From: [Rael, Rudy E.](#)
To: ["Metro, Steven J. \(Steven.Metro@wilsonco.com\)"](#)
Subject: 7816 Urraca St. NW
Date: Tuesday, November 22, 2016 4:41:00 PM

Based upon the information provided in your submittal received 11/22/16, the above referenced Grading and Drainage plan dated 11/22/16 cannot be approved for Grading Permit or Building Permit until the following comments are addressed:

GRADING AND DRAINAGE PLAN
LOT 5, BLOCK 6, UNIT 19, VCS
ADDRESS: 7816 Urraca Street, NW

GRADING AND DRAINAGE PLAN
LOT 5, BLOCK 6, UNIT 19, VCS
ADDRESS: 7816 Urraca Street, NW

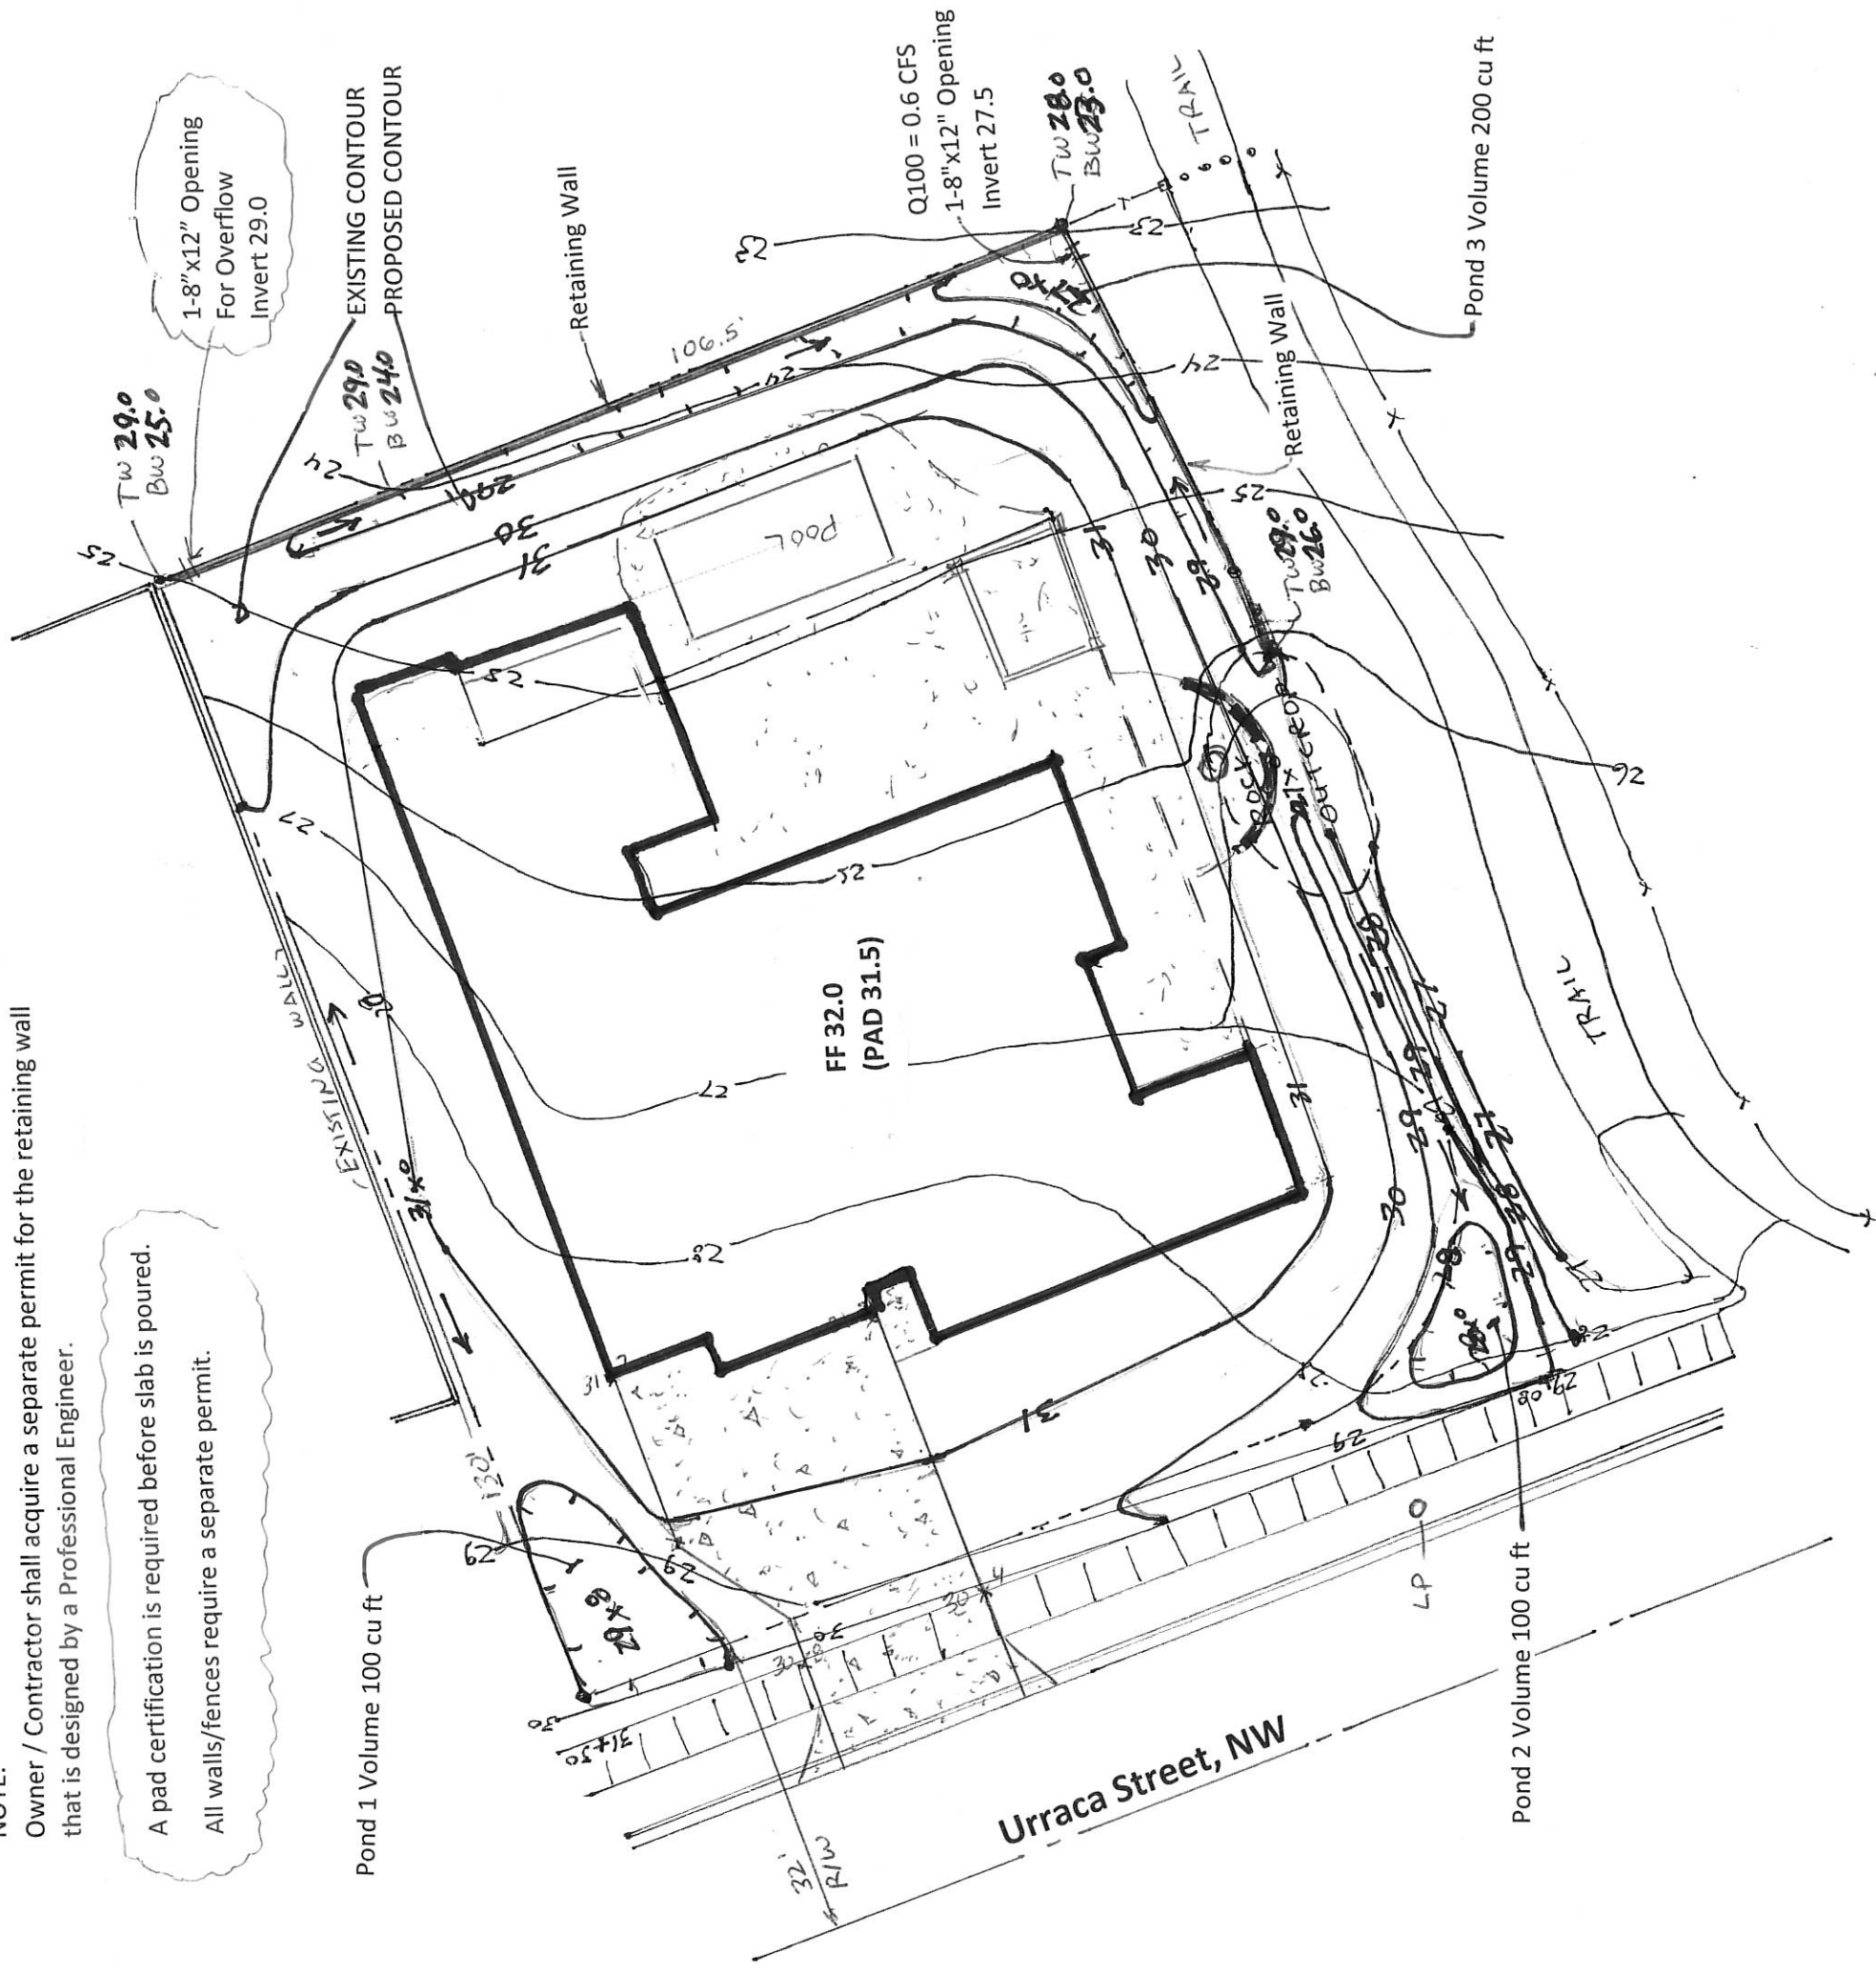
- Provide an opening in the NE corner of the wall if a block wall is to be built.
- Provide a note stating that all walls/fences require a separate permit.
- Provide a note stating that a pad certification is required before slab is poured.
